Our Ref: SDNP/18/01298/ADJAUT
Contact Officer: Victoria Corrigan
Tel. No.: 01730 819261

Neighbouring Authority Consultation

Proposal: Adjoining Authority Consultation - Arun DC - FG/33/18/PL - Demolition of polytunnels, use of land for Class B8 container self-storage & the siting of 42 No. single-stacked storage containers, an office/toilet portacabin, new fencing, gates, CCTV, lighting & alterations to the entrance.

Address: Land at Former McIntyre Nursery , Littlehampton Road , Ferring , BN12 6PG

TITLE PROPOSED SITE & BLOCK PLAN	DWG NO 5285-2	REV C
--	-------------------------	-----------------

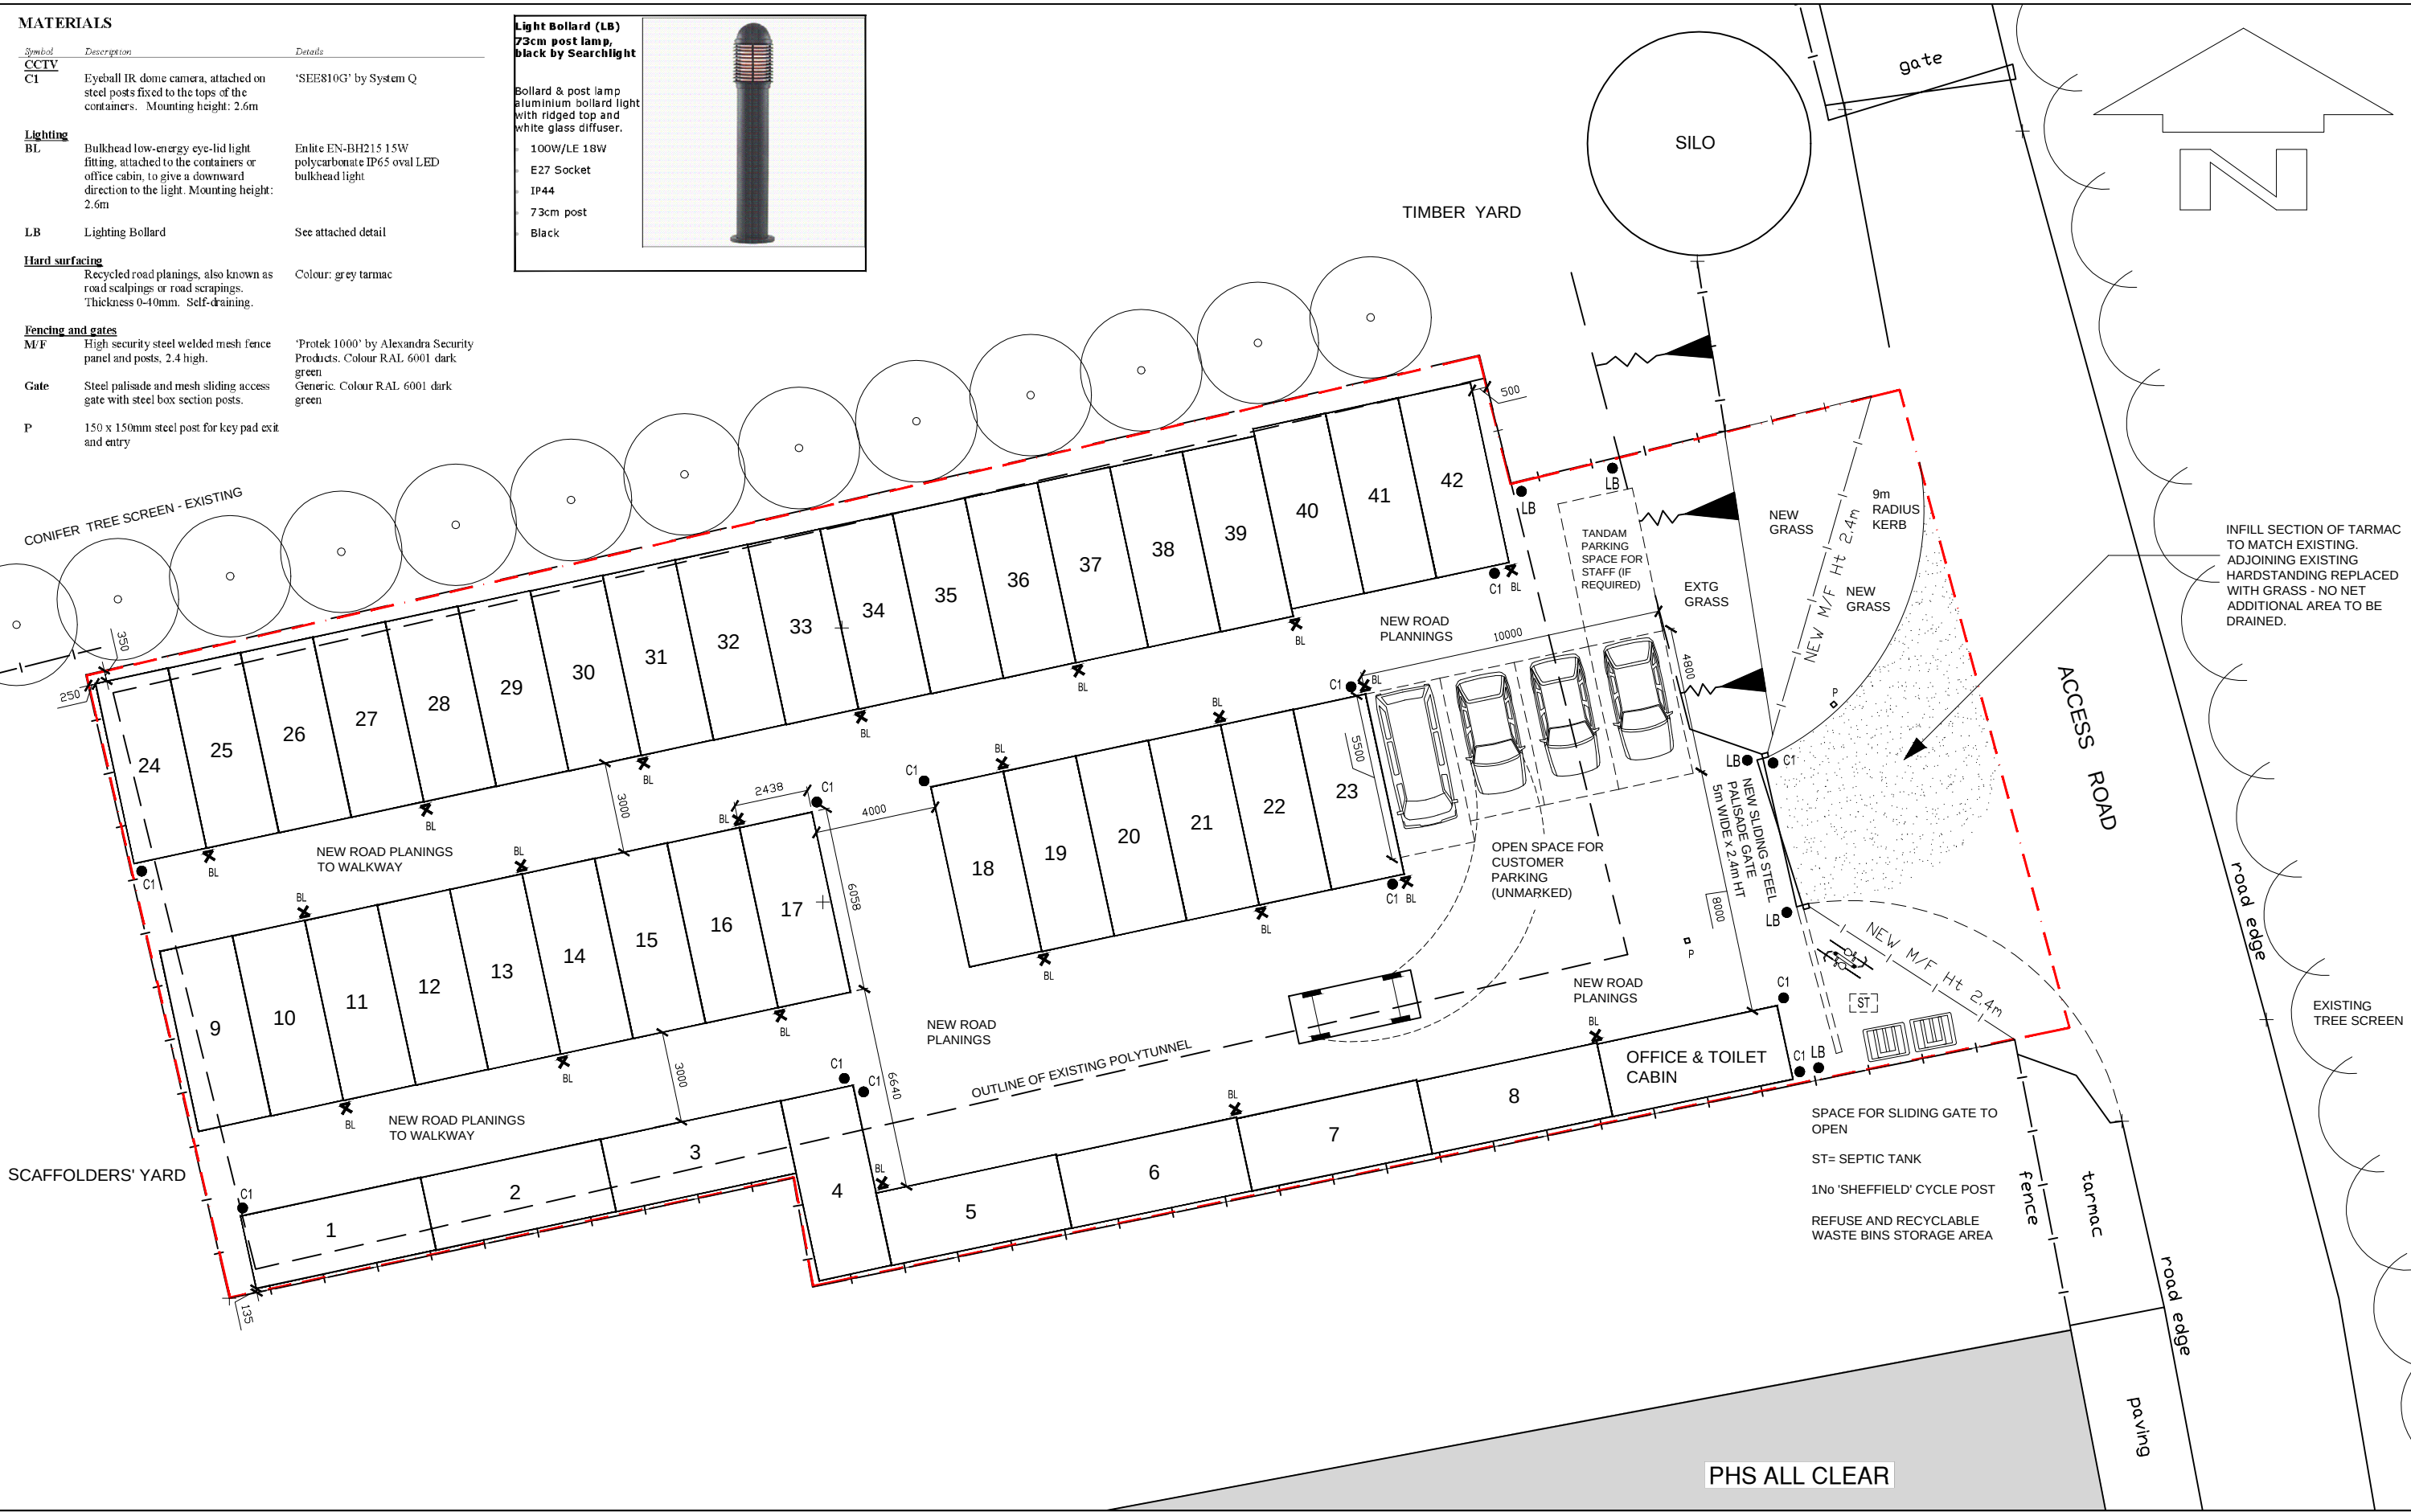
However, it has not been possible to ascertain from the lighting assessment and the fixture detail submitted how the oval light would be fitted with an eyelet, as the producer doesn't seem to give that option. Without any eyelets, these lights, although low powered, would throw light upwards above the ILP limit of around 2.5% for this area (E2) or 5% for an urban zone. The lighting design seems to suggest 50% if installed at the horizontal at the top of the container. This implies that 50% of the light would be wasted as it would be going above the containers.

It would therefore be better to install lighting that projects all lighting downwards so that the upward light ratio is zero. This is however difficult to achieve with the current design.

Also, from a wildlife perspective, a colour temperature of around 3000K is more preferable than whiter lights.

20' ISO CONTAINER STANDARD

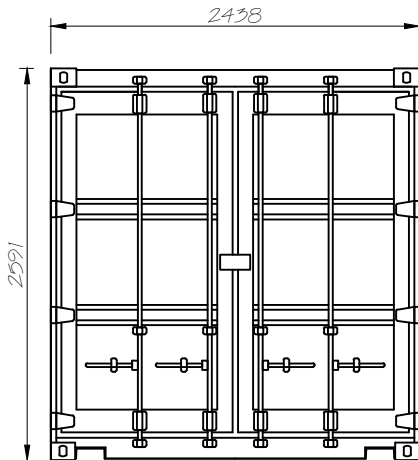
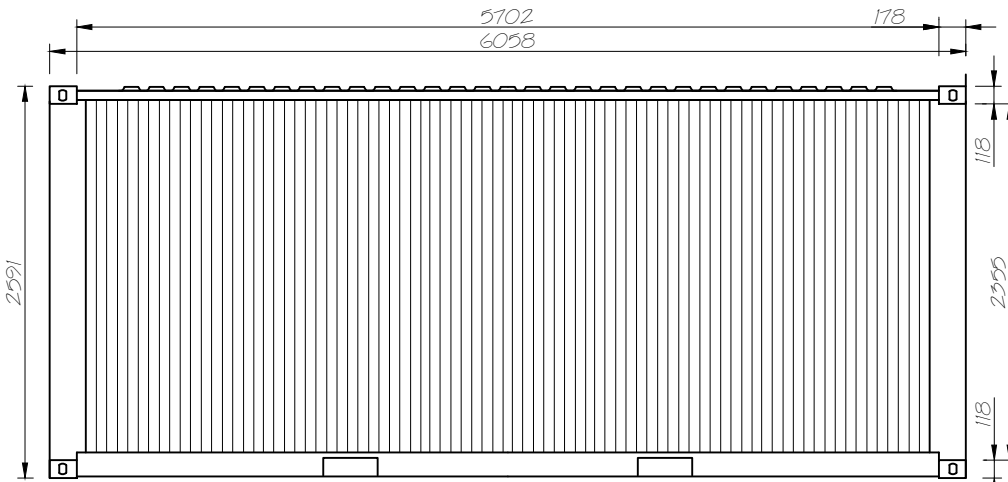
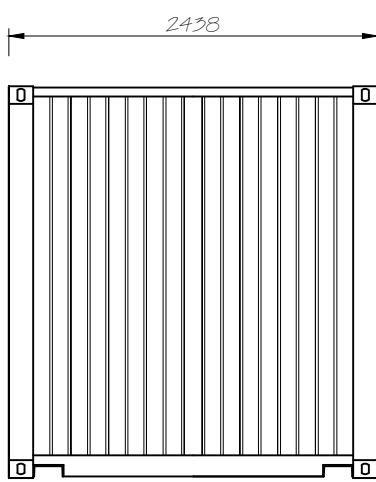
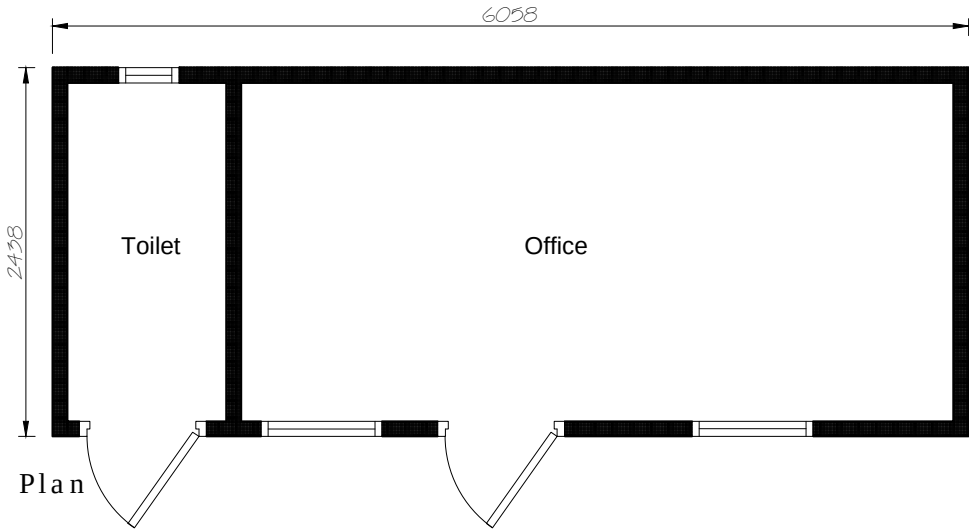
Within the submitted Planning Statement it outlines that the proposed containers would be limited in height and green in colour and that a single stack is proposed. It is recommended that a condition is attached to any permission granted to ensure that the containers are stacked as single containers at all times and sample panels should also be secured through a condition for the colour of the containers to ensure that the chosen colour blends in with the landscape as much as possible.
